10/2/2020

Mercer Island Dept. of Building and Construction

RE: Response to Intake comments

SET TITLE: PERMIT SET  
SHEET TITLE: SITE PLAN

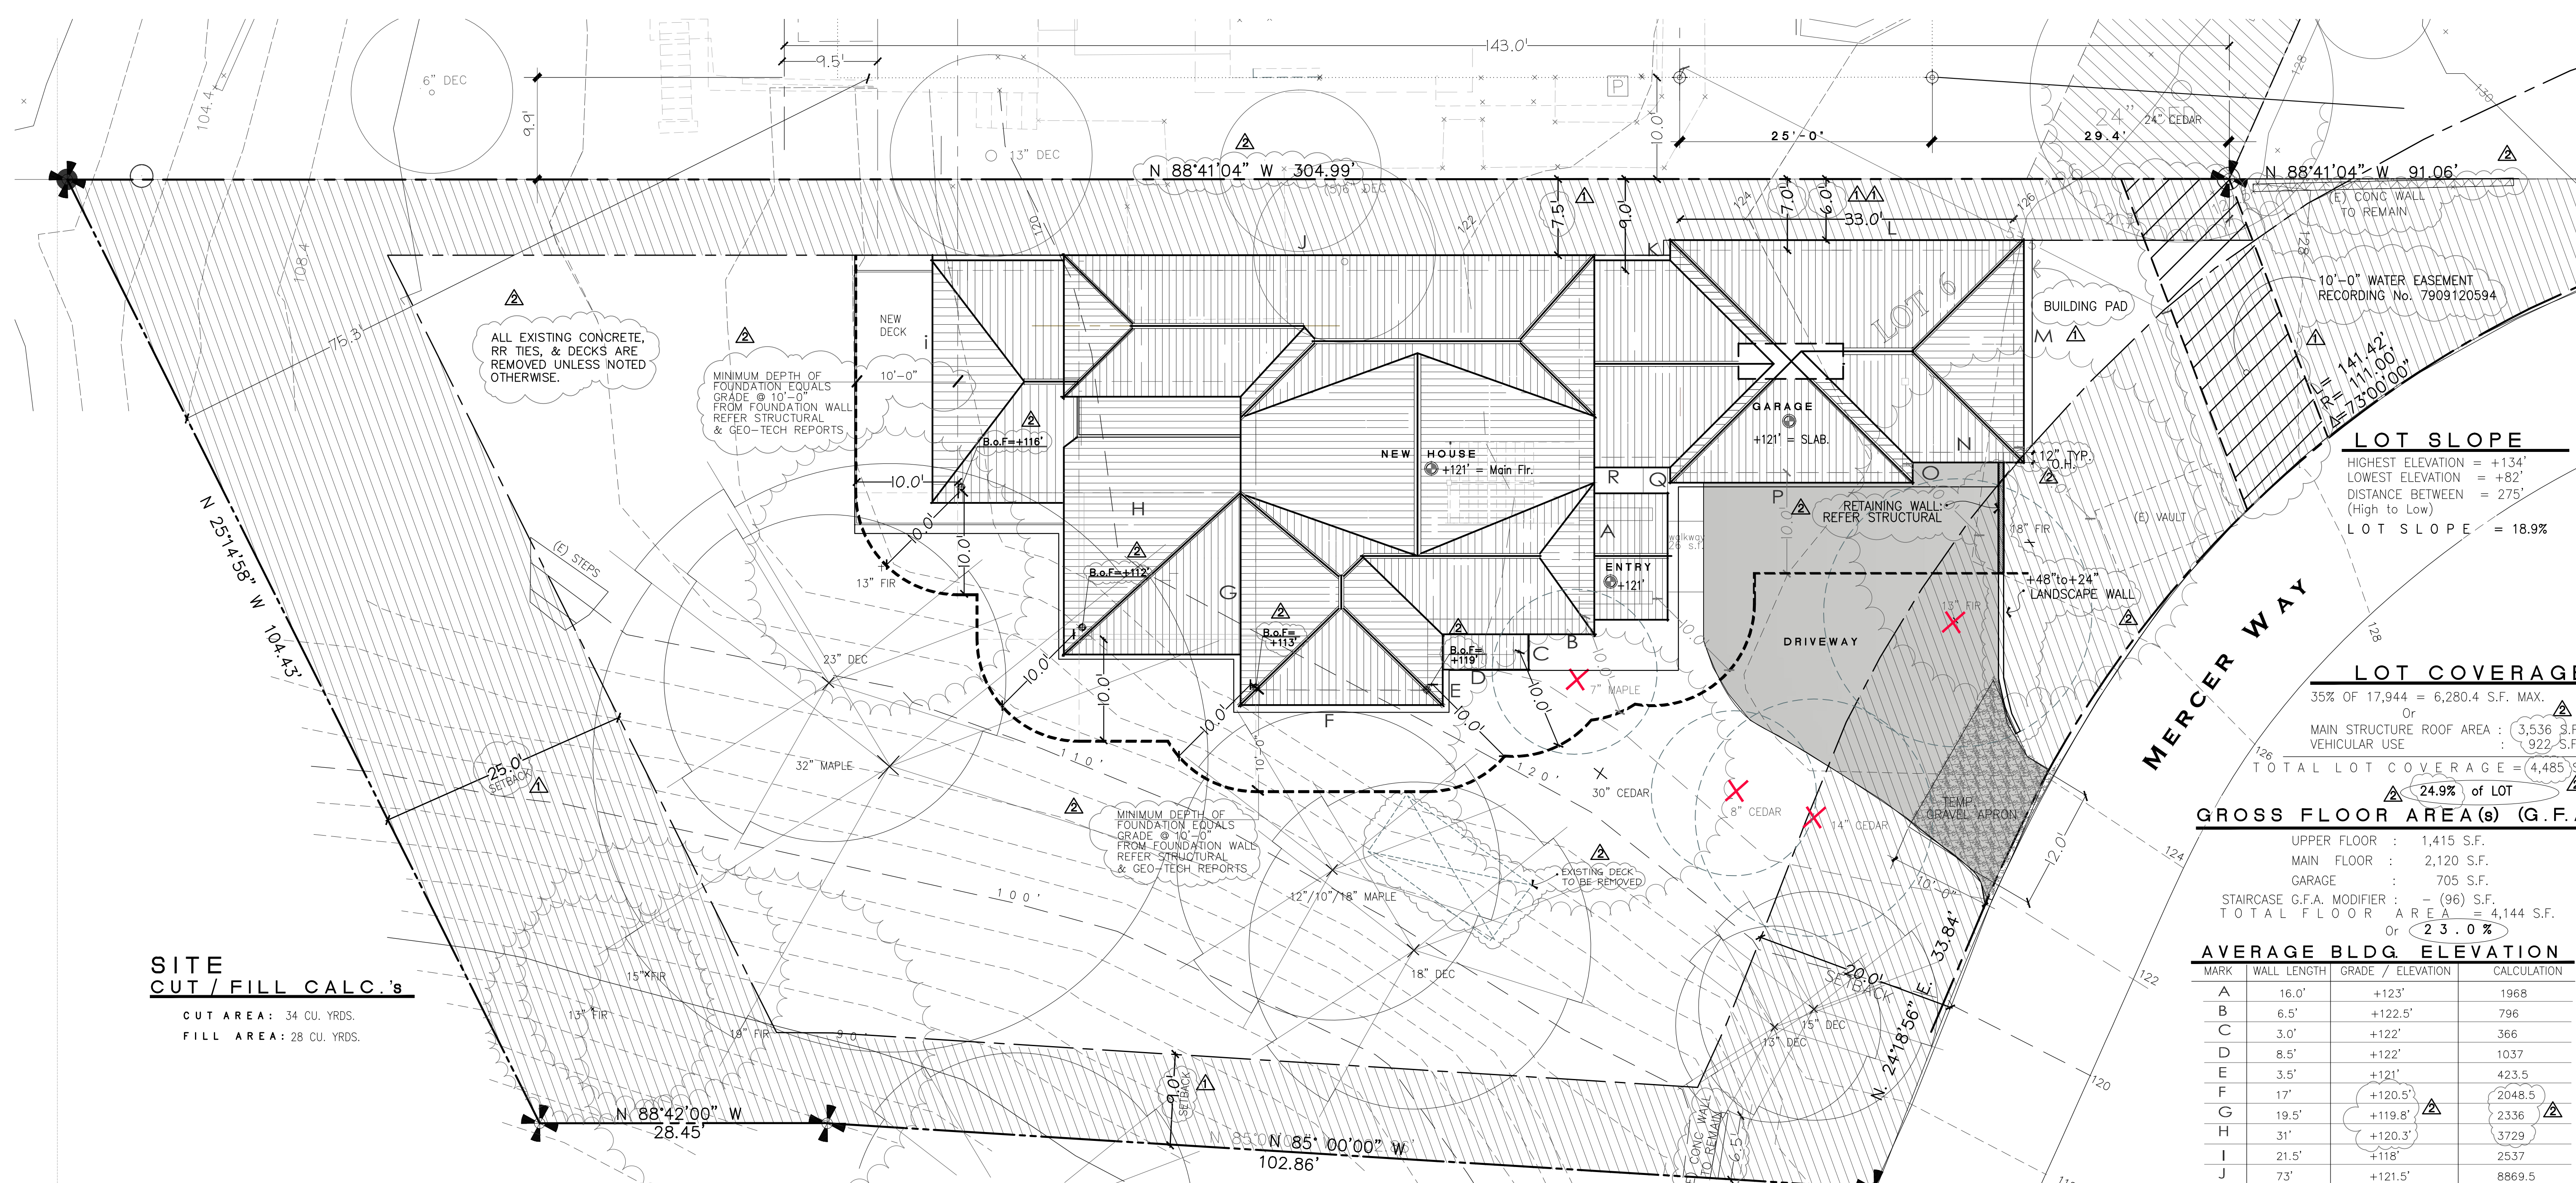
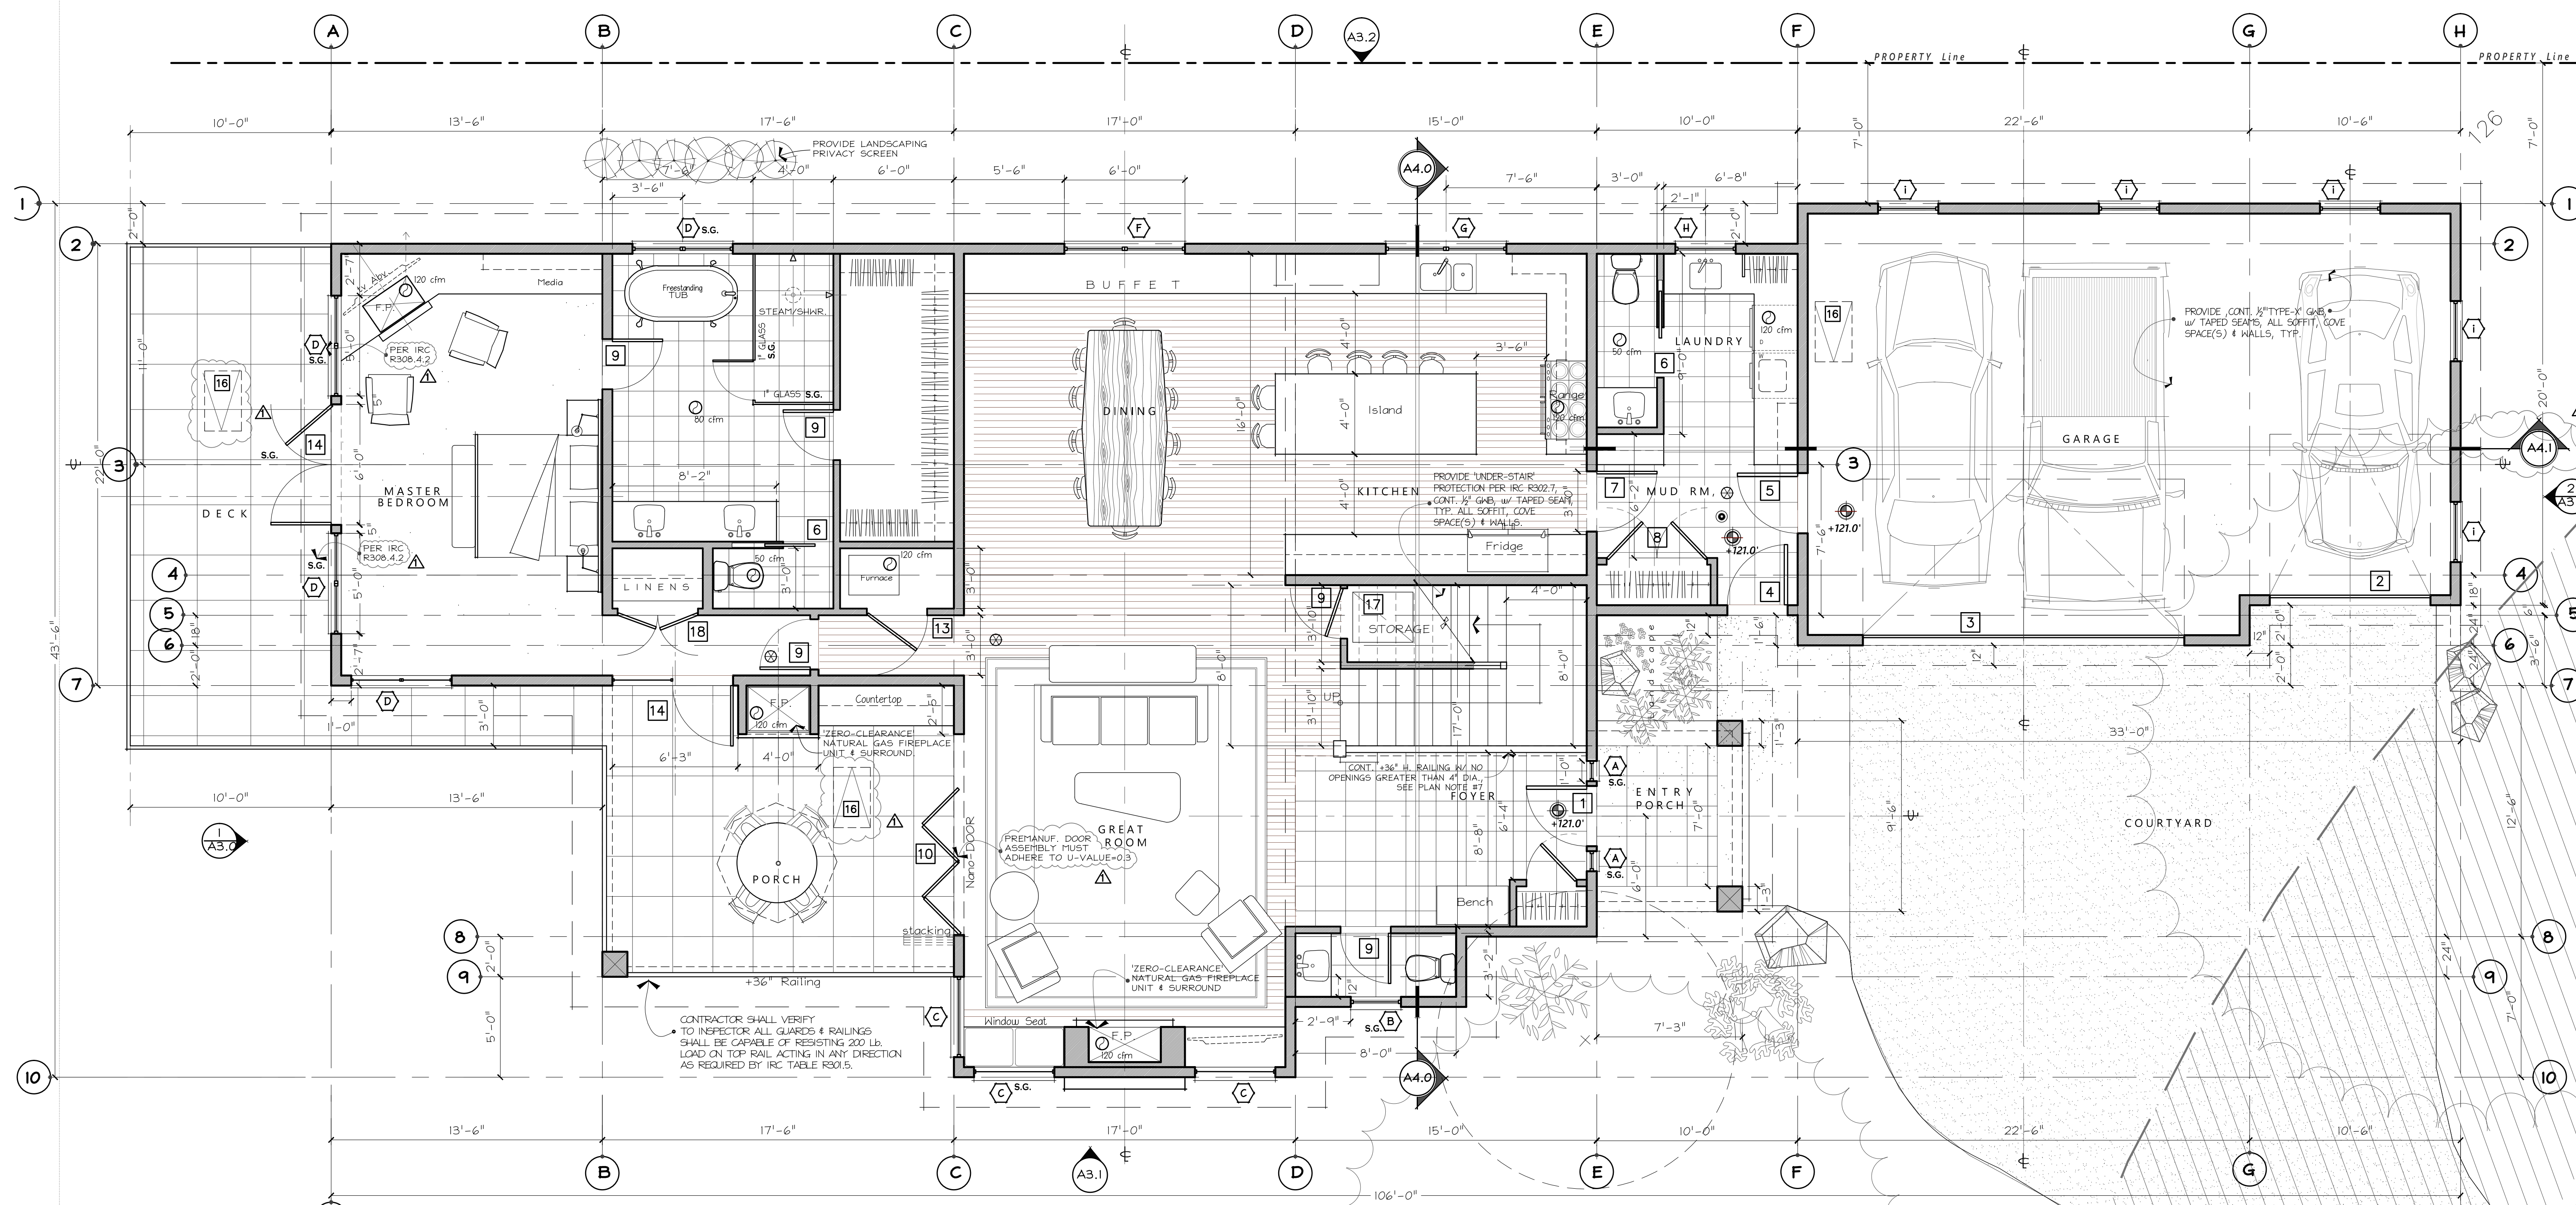
- Building pad and all setbacks added to A1.0
- Utility easement and recording date added to A1.0
- Exemption from a SDP affidavit for a SSDP uploaded
